RE: Downs Short Plat (SP-12-00007)

## MEMORANDUM

TO: Phil Rigdon, Deputy Director, DNR  
THROUGH: Scott Nicolai, Yakima Subbasin Habitat Coordinator, YKFP  
FROM: John Marvin, Habitat Biologist, YKFP  
DATE: Tuesday, January 15, 2013  
RE: Downs Short Plat (SP-12-00007)

Kittitas County is accepting public comments on the Downs Short Plat (SP-12-00007) until January 22, 2013. The project proposes to subdivide 23.71 acres into 2 single-family lots of 11.14 acres and 12.42 acres with water provided by individual wells. The proposal is located approximately 6 miles northeast of Cle Elum, along the Teanaway River.

DOWN'S SHORT PLAT
PART OF SECTION 14, T. 20 N., R. 16 E., W.M.
KITITAS COUNTY, WASHINGTON

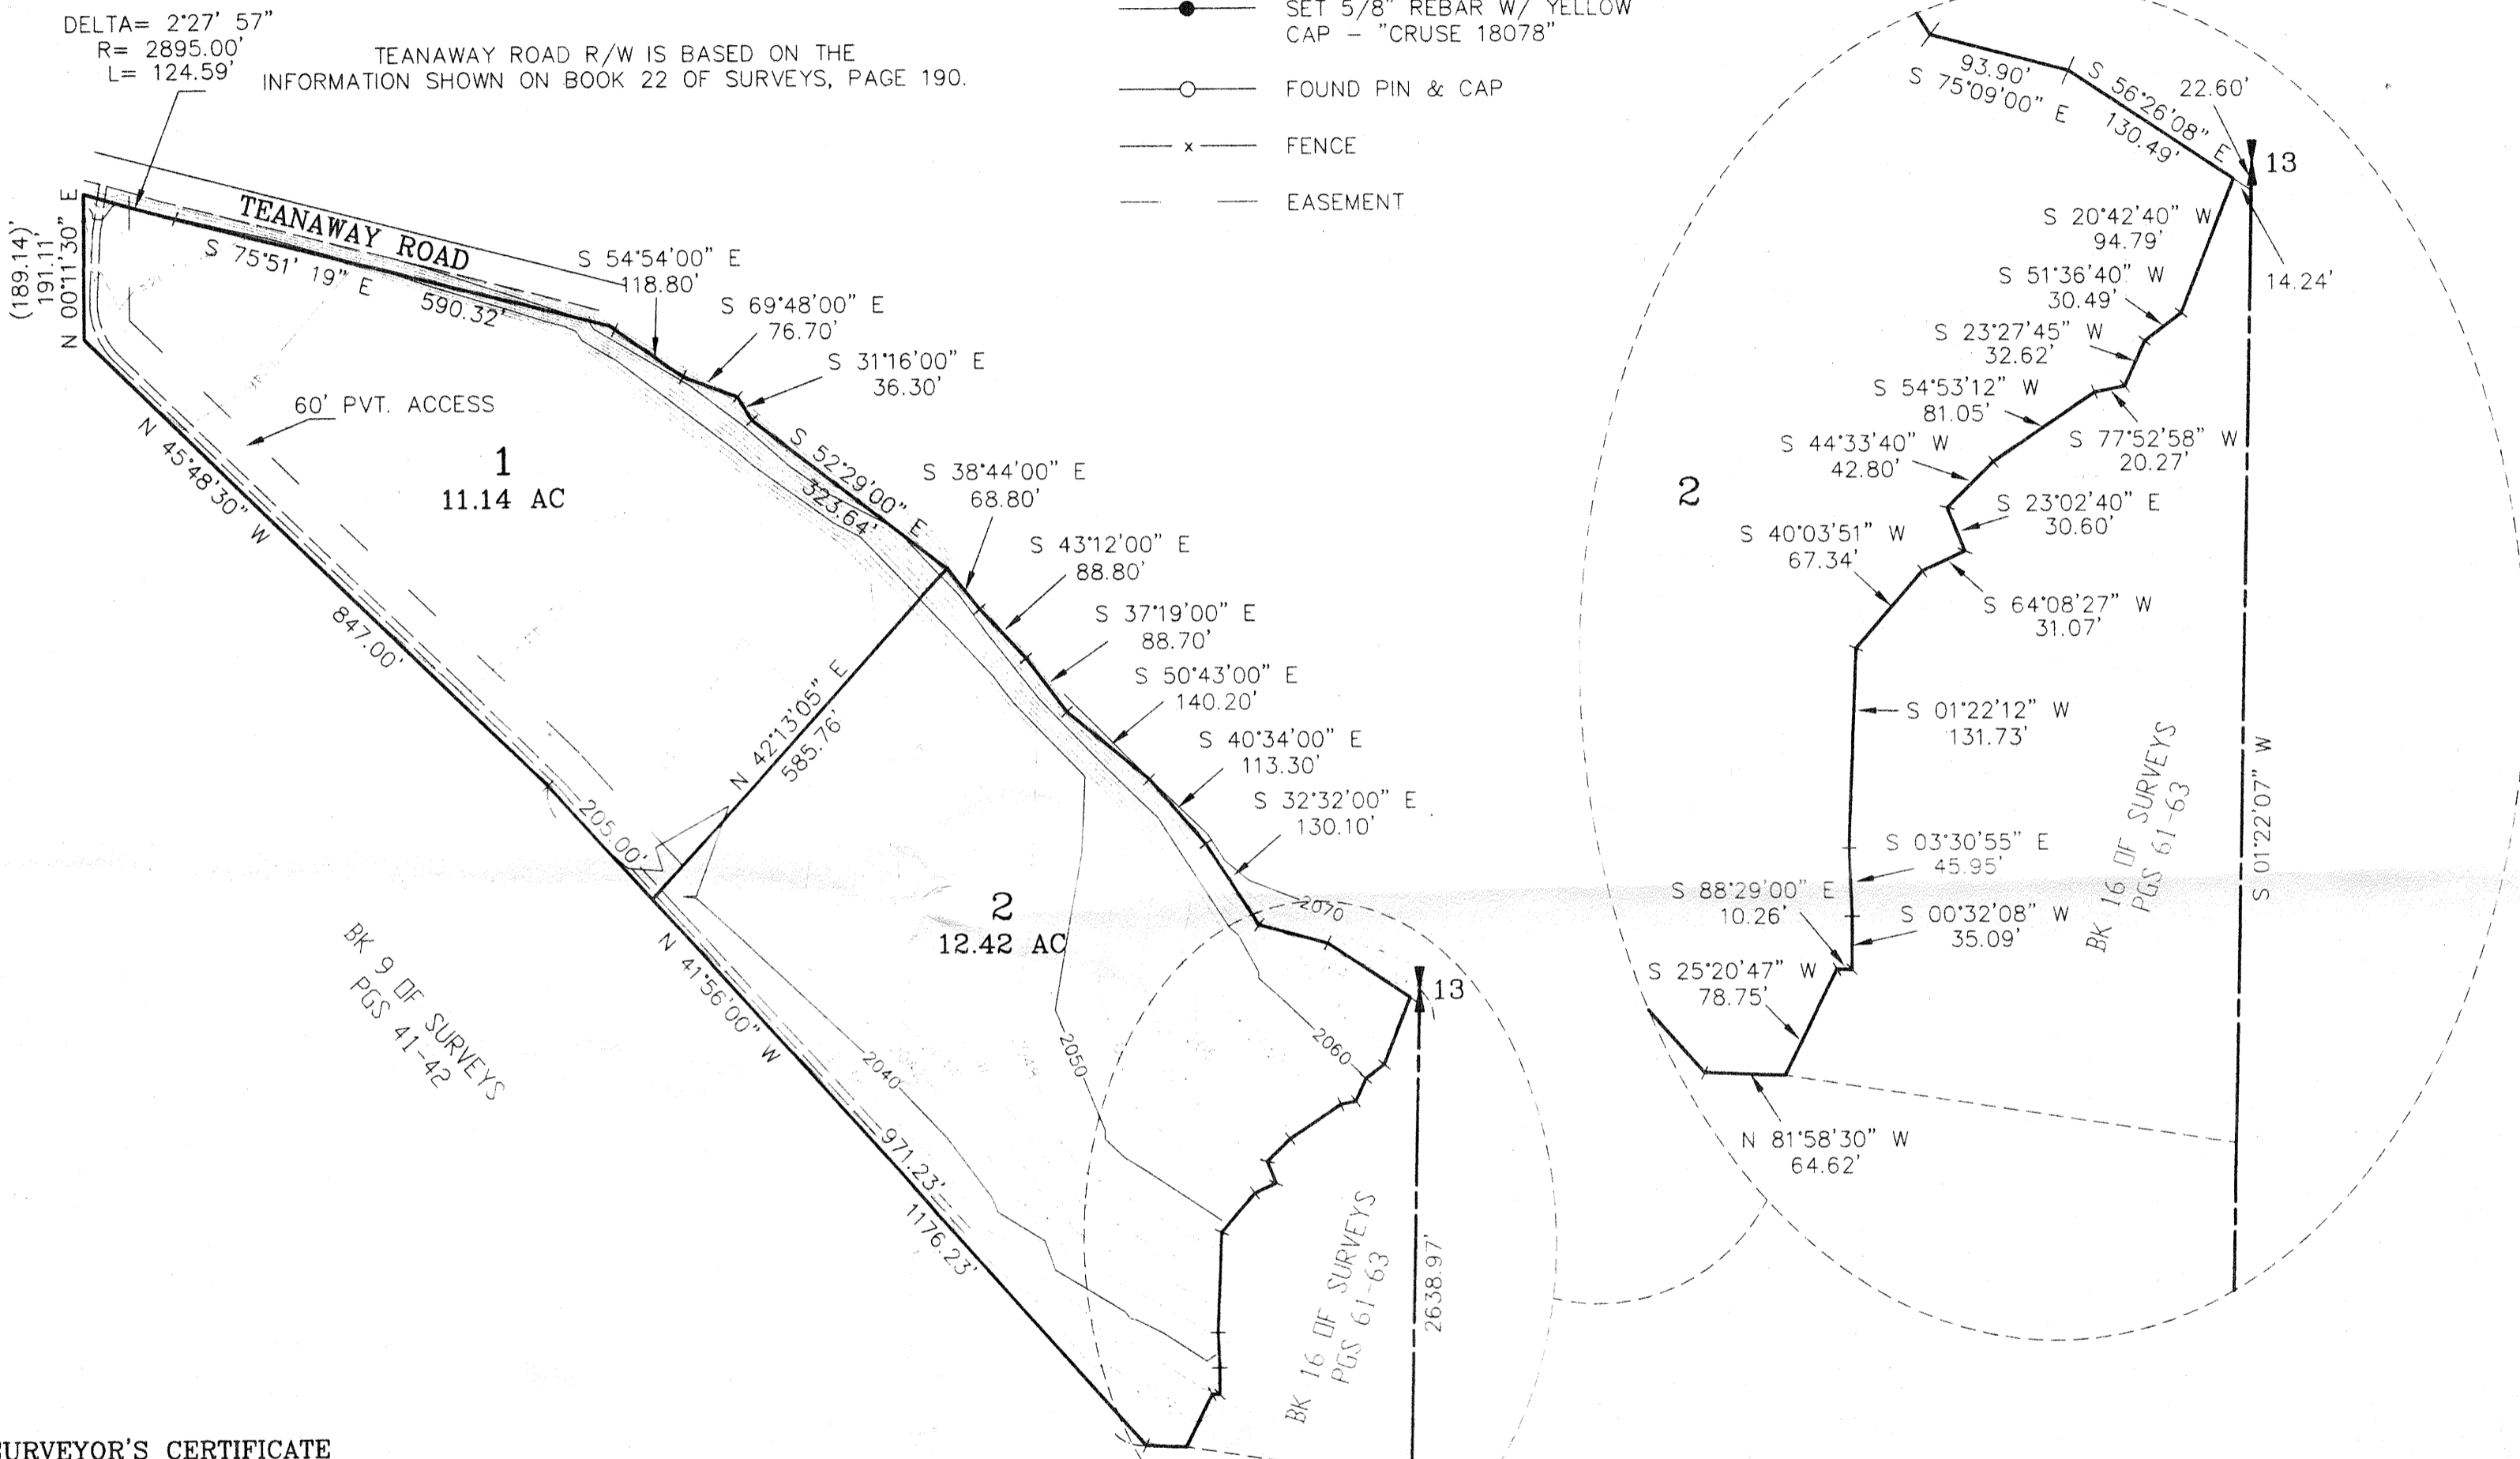
The proposal lies at the confluence of Mason Creek and the Teanaway River, with the southeastern property line being the right bank of Mason Creek.

The Teanaway River is a Shoreline of Statewide Significance under the Shoreline Management Act (SMA) (RCW 90.58) and regulated by the Kittitas County Shoreline Master Program (SMP) and the SMA. According to the SMA and the SMP, Shoreline jurisdiction is never less than 200 feet from the ordinary high water mark (OHWM). While a field survey has not been completed, a review of aerial photographs indicates that at least some of the proposal is within SMA jurisdiction. There also appear to be a

number of associated wetlands directly adjacent to the proposal, with wetland buffers potentially extending onto the subject property.

Kittitas County is currently in the process of a comprehensive update of its SMP, which to date has provided draft maps of a channel migration zone (CMZ). The draft CMZ maps indicate that half of the proposed sub-division is within the CMZ, with the other half encompassed by the alluvial fan from Mason Creek (Attachment A). Both the CMZ and alluvial fan are geologically hazardous areas that may not be appropriate for residential development.

Recent LIDAR(Light Detection And Ranging) data acquired by the Yakama Nation in the Teanaway Basin indicates that the southwestern boundary of the proposal may consist of a dike or other kind of flood control structure. The SMA and Kittitas County have been regulating land use in SMA jurisdiction since 1971, and a flood control structure constructed since 1971 would require a substantial develop permit.

Mason Creek is a designated critical area under the Growth Management Act (RCW 36.70A) and regulated by the Kittitas County Critical Areas Ordinance (CAO) (KCC 17A). Mason Creek should be designated as a Type 2 water, with an associated 100 foot riparian buffer. A review of aerial photographs indicates there may be two potential wetlands along the southwestern parcel line, in addition to numerous potential wetlands directly adjacent to the southwest parcel line.

- The proposal is within jurisdiction of, and should be required to conform to Chapter 173-539A WAC. The proposal should also be required to be consistent with the findings of the Washington State Supreme Court (Court) in its opinion in Kittitas County v. Eastern Washington Growth Management Hearings Board (Board) (No. 84187-0).
- The proposal is within jurisdiction of, and should be required to conform to the Kittitas County Shoreline Master Program and the Shoreline Management Act (RCW 90.58).
- The proposal is within jurisdiction of, and should be required to conform to the Kittitas County Critical Areas Ordinance (KCC 17A).
